SUBJECT: Engineering Review Comment
Mountain View Electric Association Inc. (MVEA)

Project Name: Lazy Y Minor Subdivision

Project Number: SF2429

Description: Proposed development of one residential lot located west of Peyton Hwy and south of US Hwy 24 in Township 12S, Range 63W, Section 7.

LAZY Y AND ROCKING J SUBDIVISION

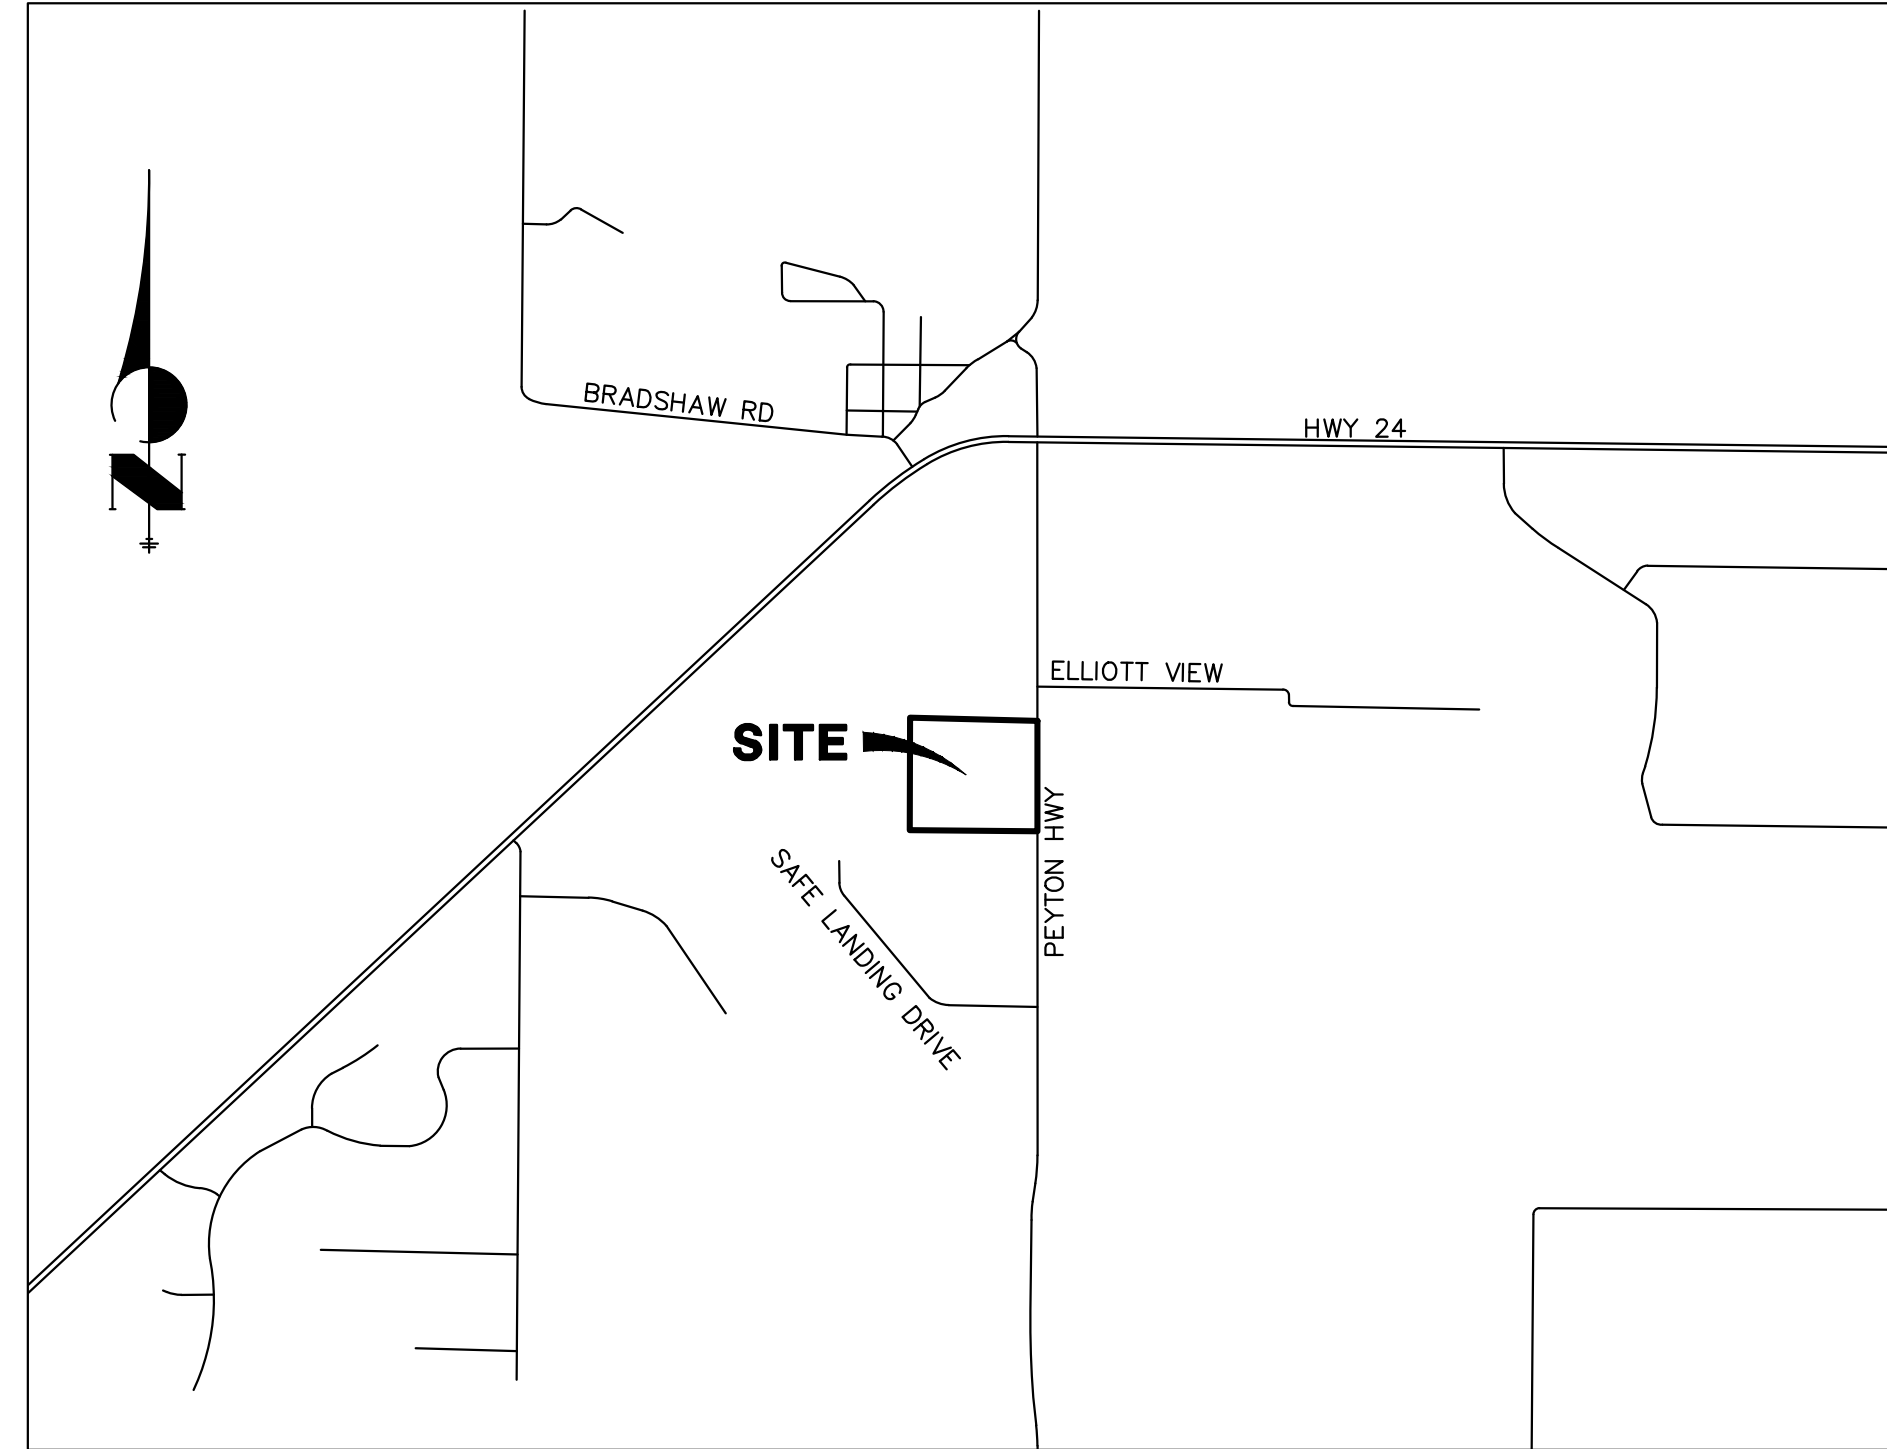
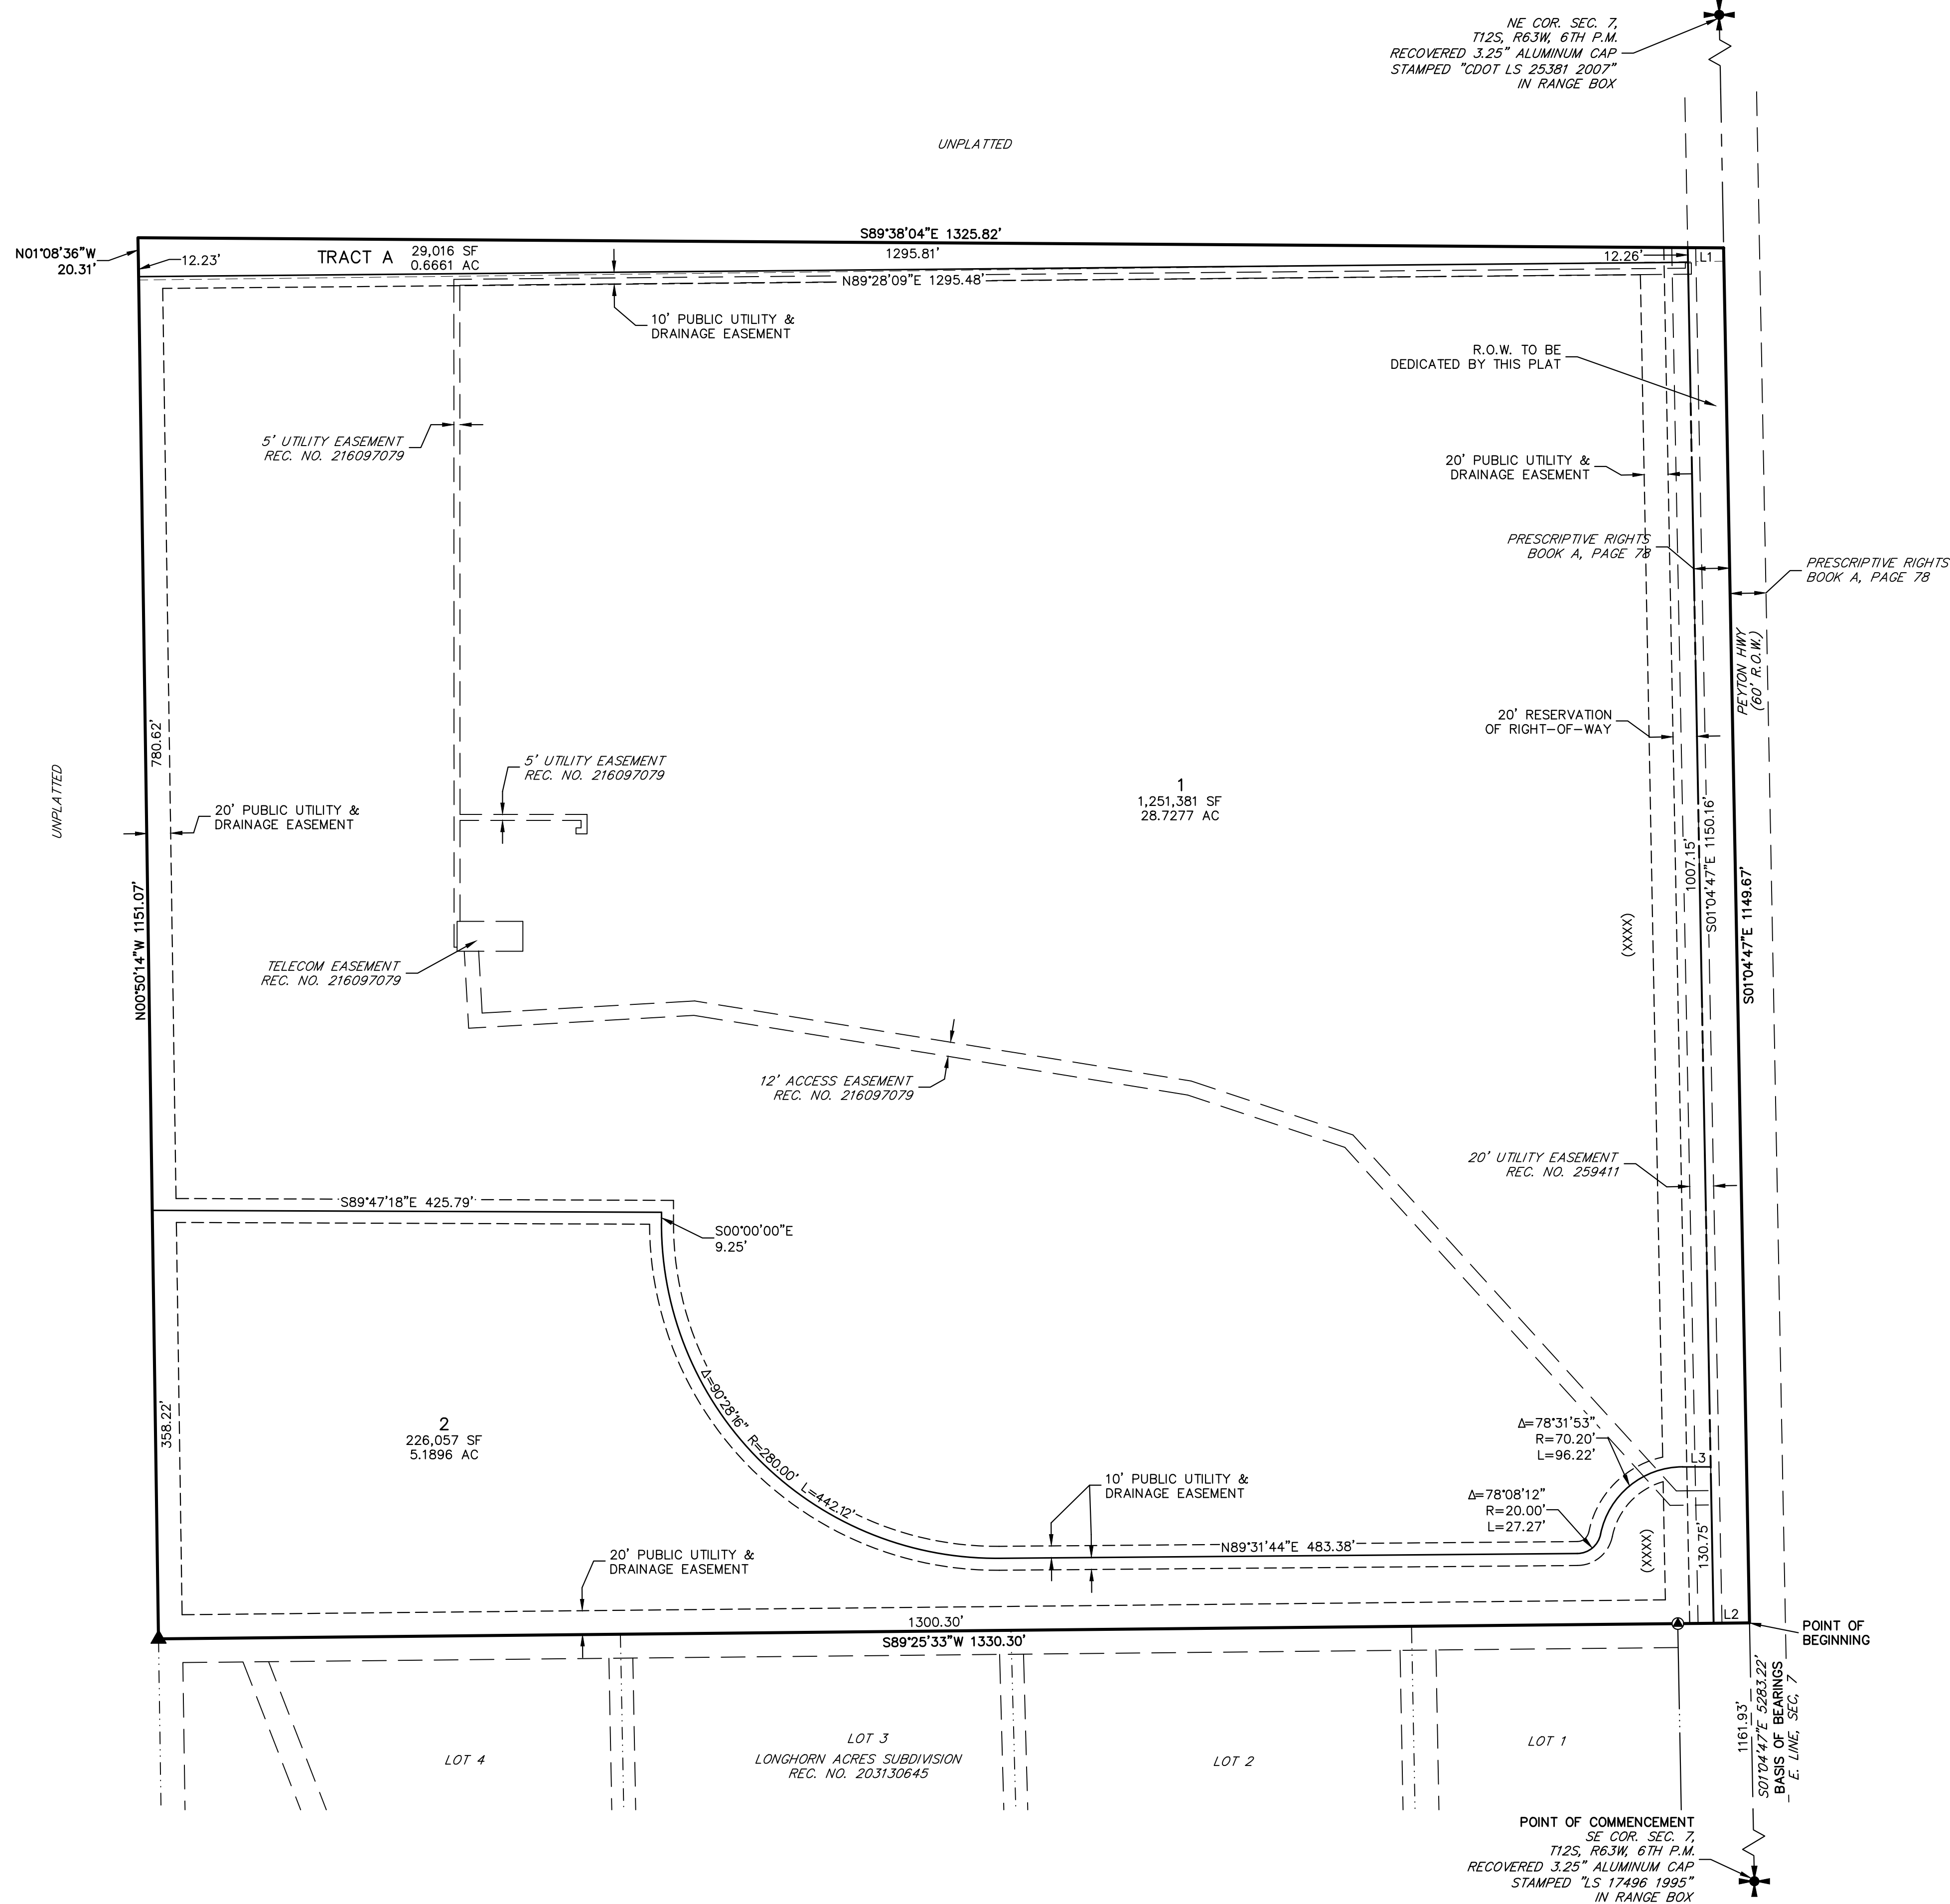
MVEA requests twenty (20) foot front, side, and rear utility easements and will work with the developer on the design of the electric service and to acquire any additional easements. MVEA also requests the platting of MVEA's existing facilities with easements on the plat.
